Laurie Leader - Re: 120 Noyes Street BP#2014-00342 Plan review comments

From: Laurie Leader
To: Muto, Gerald
Date: 3/17/2014 9:58 AM
Subject: Re: 120 Noyes Street BP#2014-00342 Plan review comments

I have completed the review of the above project for building code and have the following comments as noted on the attached files.

**A-100**

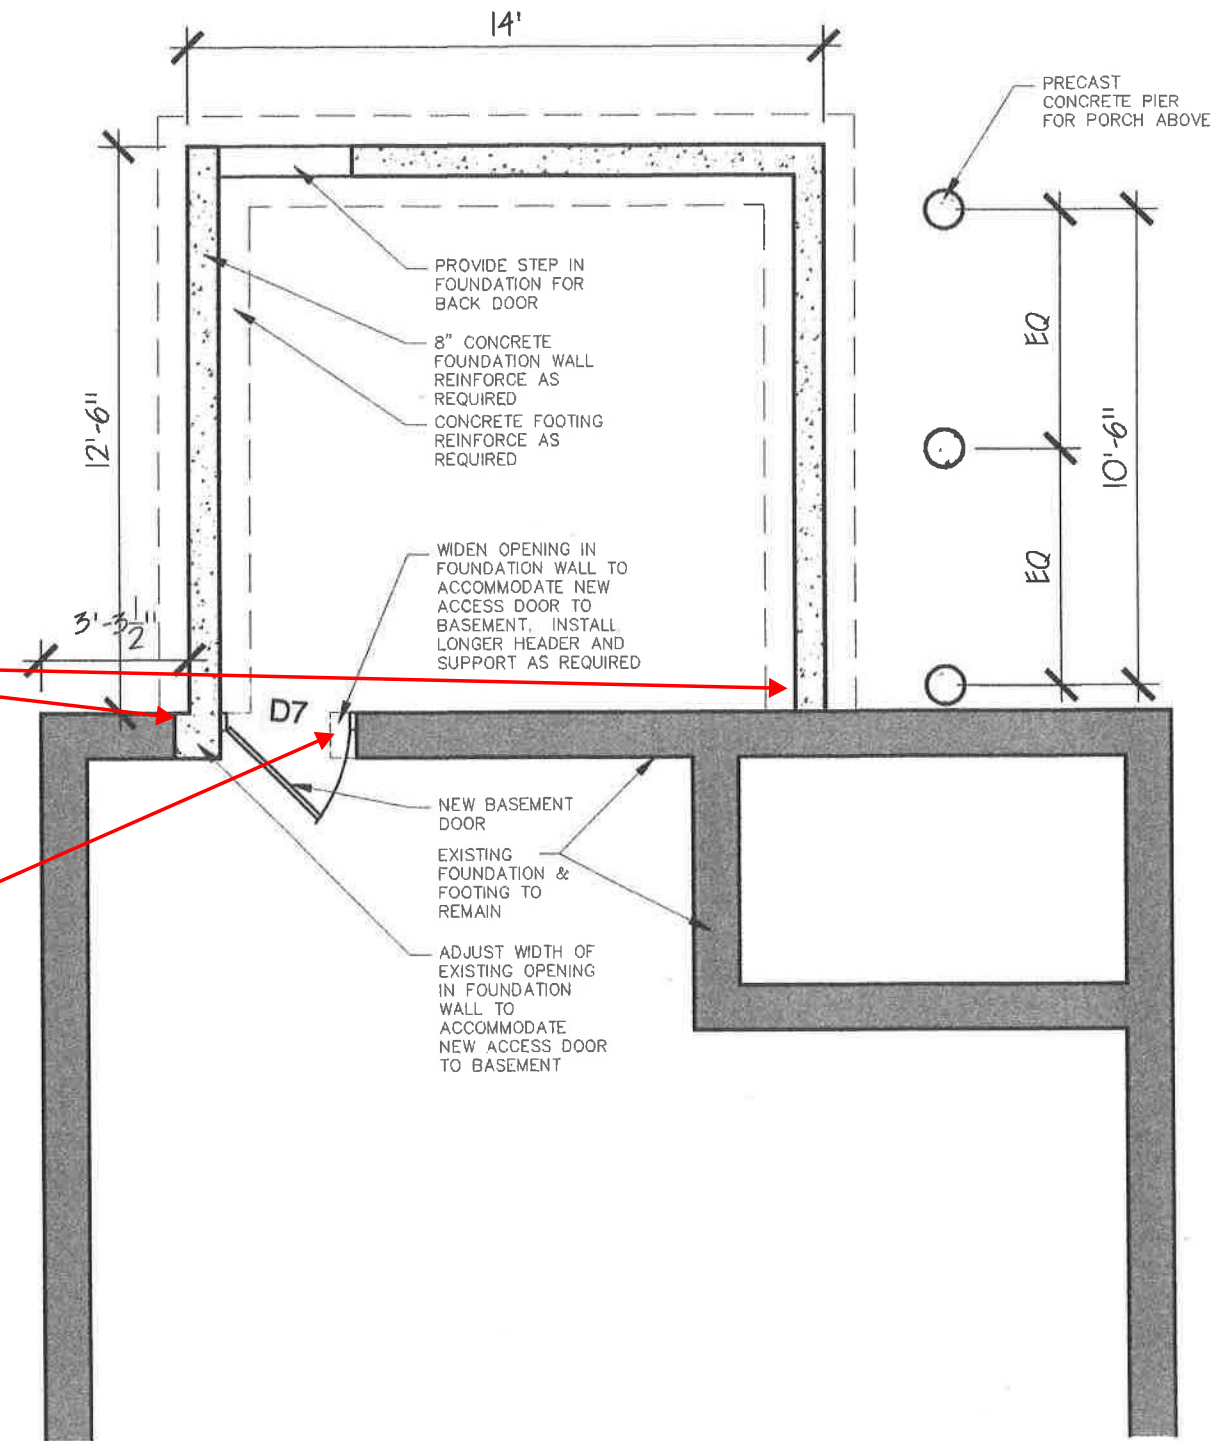
A-100 Foundation Plan

-New Foundation Anchoring- pins will be drilled into the existing foundation and tied into rebar in foundation.

-header over basement door- 4- 2x8 kid screwed together as a header (to match existing floor framing)

A-101

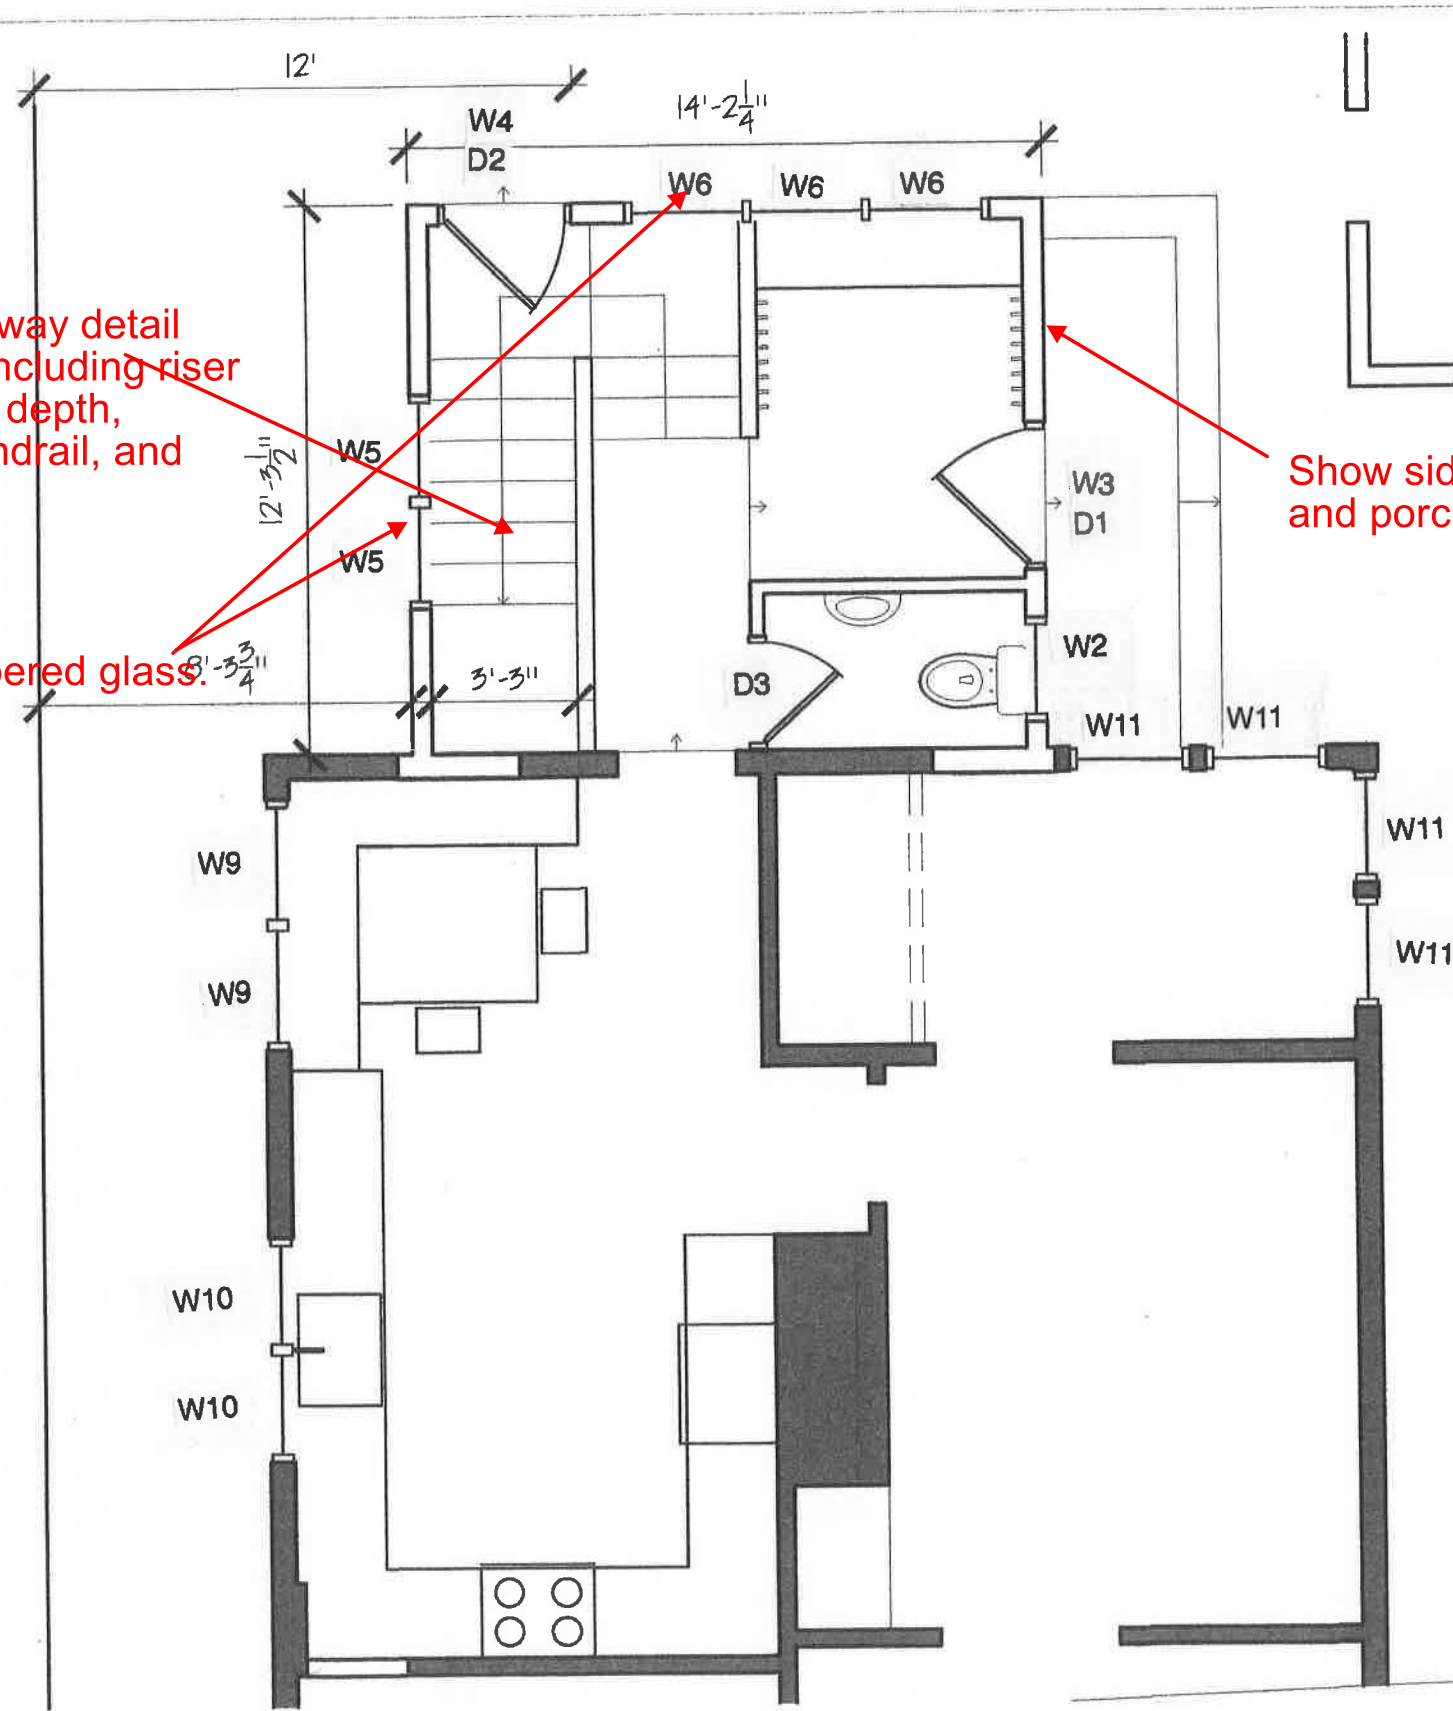
A-101 First Floor Plan

- stairway -rise is 7 $\frac{3}{8}$ " , run is 10" , tread is 11" , railing is continuous at 36" from nose

-headroom is to 6'8" or as much as possible **Must be 6'8" or greater**

- tempered glass as you have indicated (windows have not been ordered)
- Porch Details-framing to be 2x8 pressure treated, only 2 rises of 7&3/8" supported a triple 2x8 beam which is supported by footing tubes 48" or greater into ground. Joists will be hung from floor rim by joist hangers. Decking to be Azek.

**A-102**

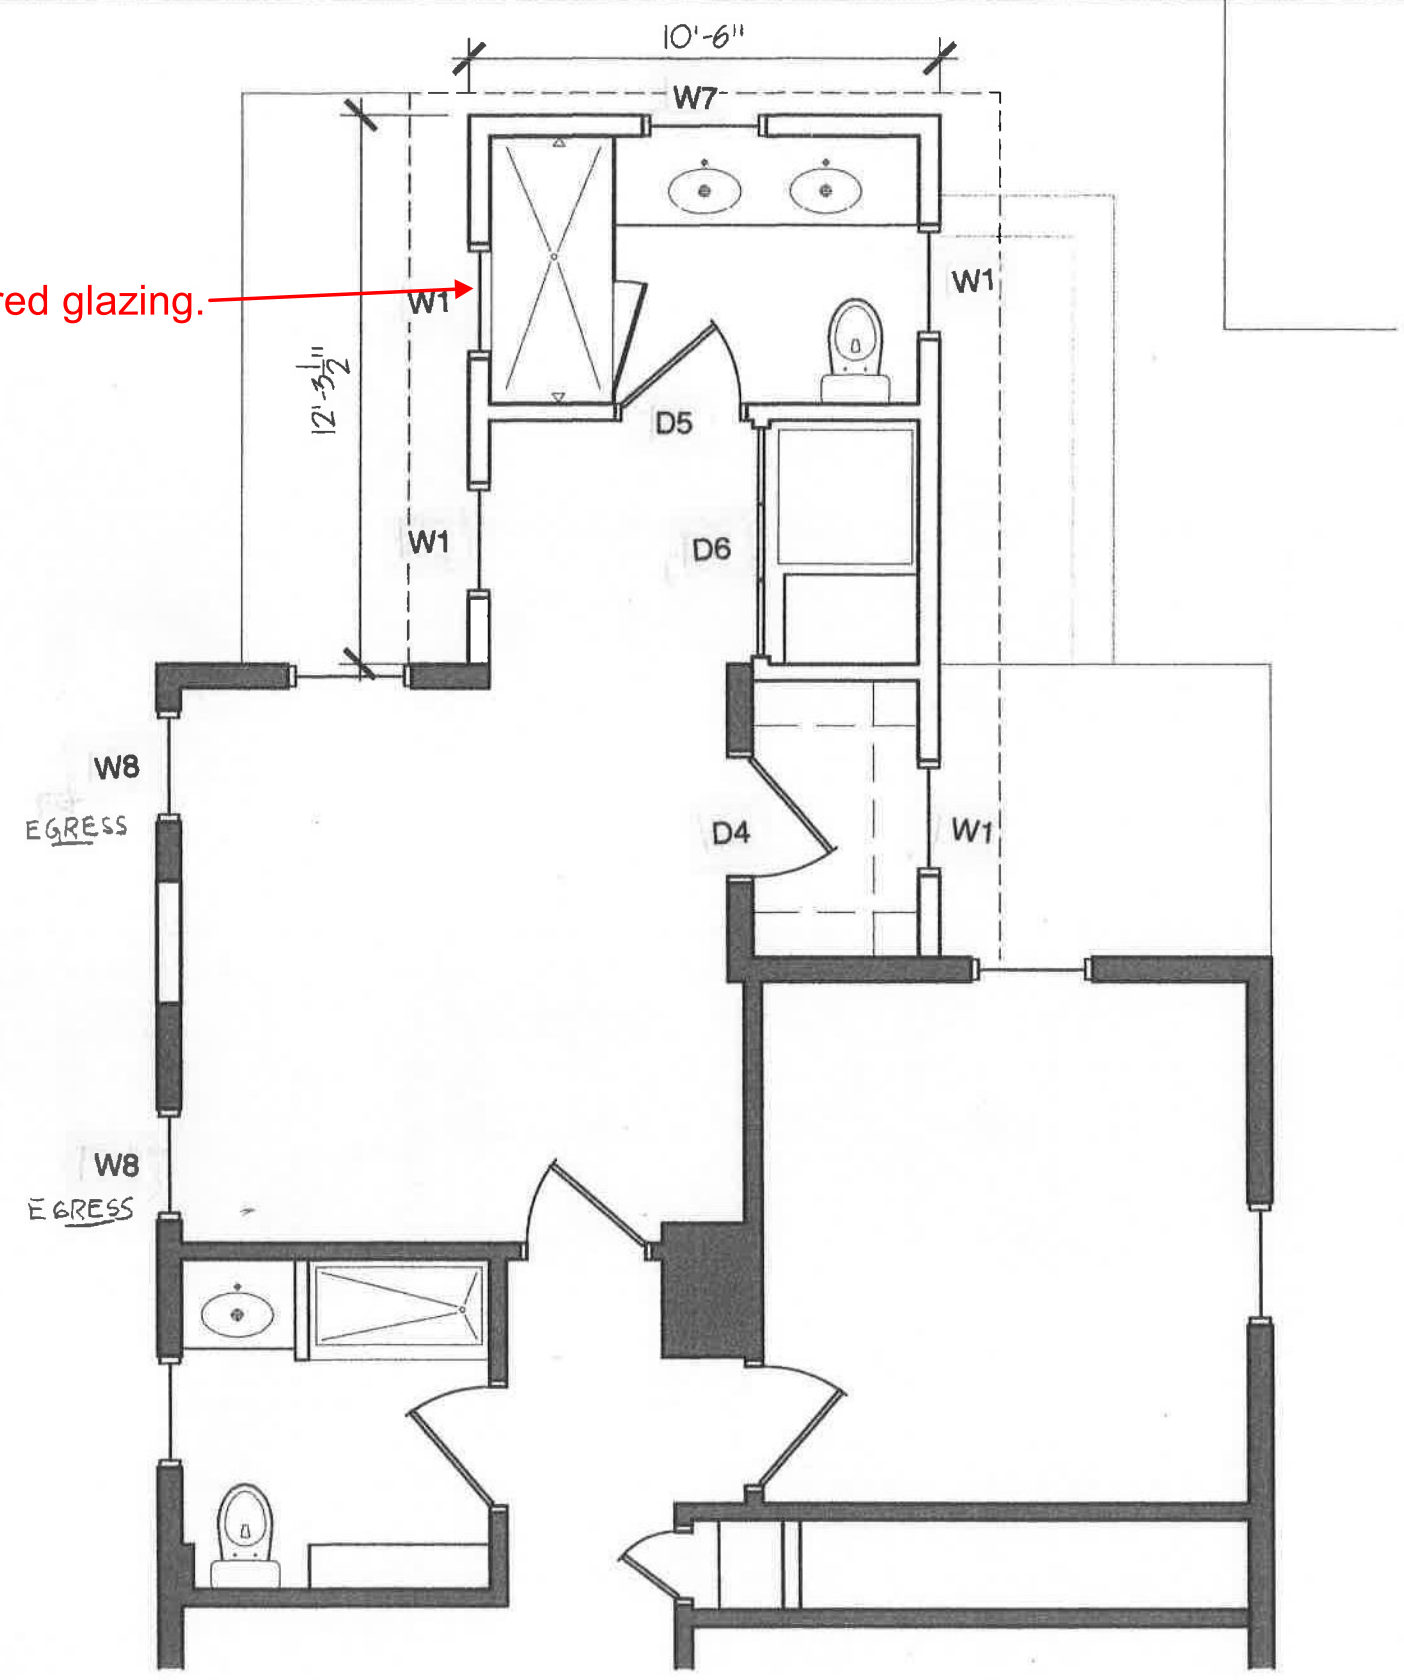
A-102 Second Floor Plan

- tempered window in Shower (again the windows are not ordered.)

## CROSS SECTION

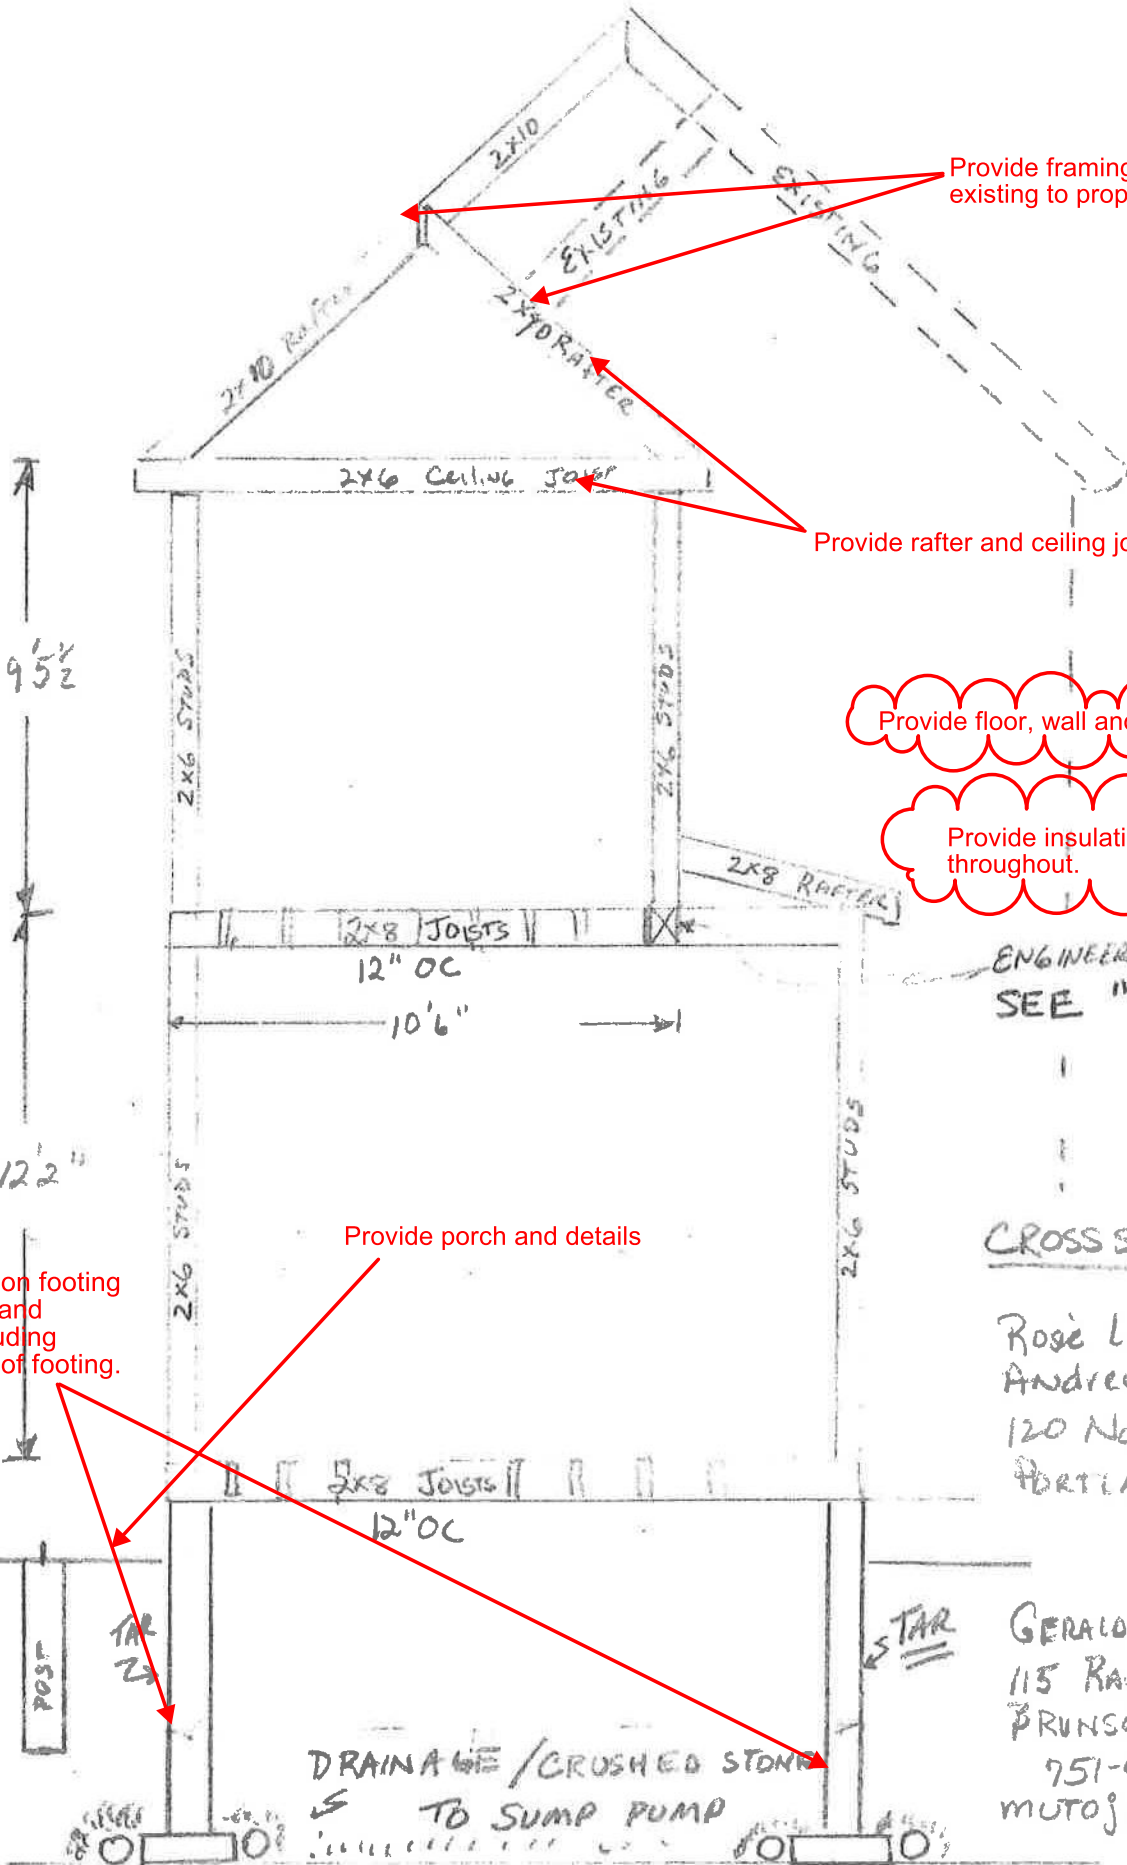
So to make the remainder of the basement 6'8" headroom, the new floor would have to be much below the existing one. The math is 6" to make up for the existing headroom at 6'2", another 6" because of the first step out of the kitchen, and 7.25" for the second step in the entrance floor, for a total of 19.25".

Is there anything in the code that might allow us to leave the new basement floor even with the existing basement floor?

Framing Crosssection

- rafter and ceiling joist framing is 16" oc
- all floor sheathing is 3-4" Advantech
- all wall sheathing is 1/2" CDX Plywood
- all roof sheathing is 5/8" Advantech
- insulation values on A-101, but are as follows:
 - walls R-26
 - roof. R-50
 - all rim joists R-26
 - all MEP penetrations air sealed
 - vent channels as needed
- Framing tie in details- new ridge pole set in existing wall the depth of the existing wall framing, supported by studs/posts to ground.
- foundation to be 8" wide, supported on a footing that is 16" wide and 8" deep,with footing set so new cement floor lines up with existing.
- Porch details -see A-101

A concrete floor in this additional uninhabitable space, drainage underneath leading to a sump pump, crushed stone and a vapor barrier will meet code. The foundation walls will need to be damp proofed as shown on the plans. The permit approval will include a copy of changes according our discussion per this email.

Below are the basement, ventilation and access standards. If you provide vapor barrier and a concrete slab, you will not need to provide ventilation. If you do not have a slab, you will need to provide ventilation according the code as described below.
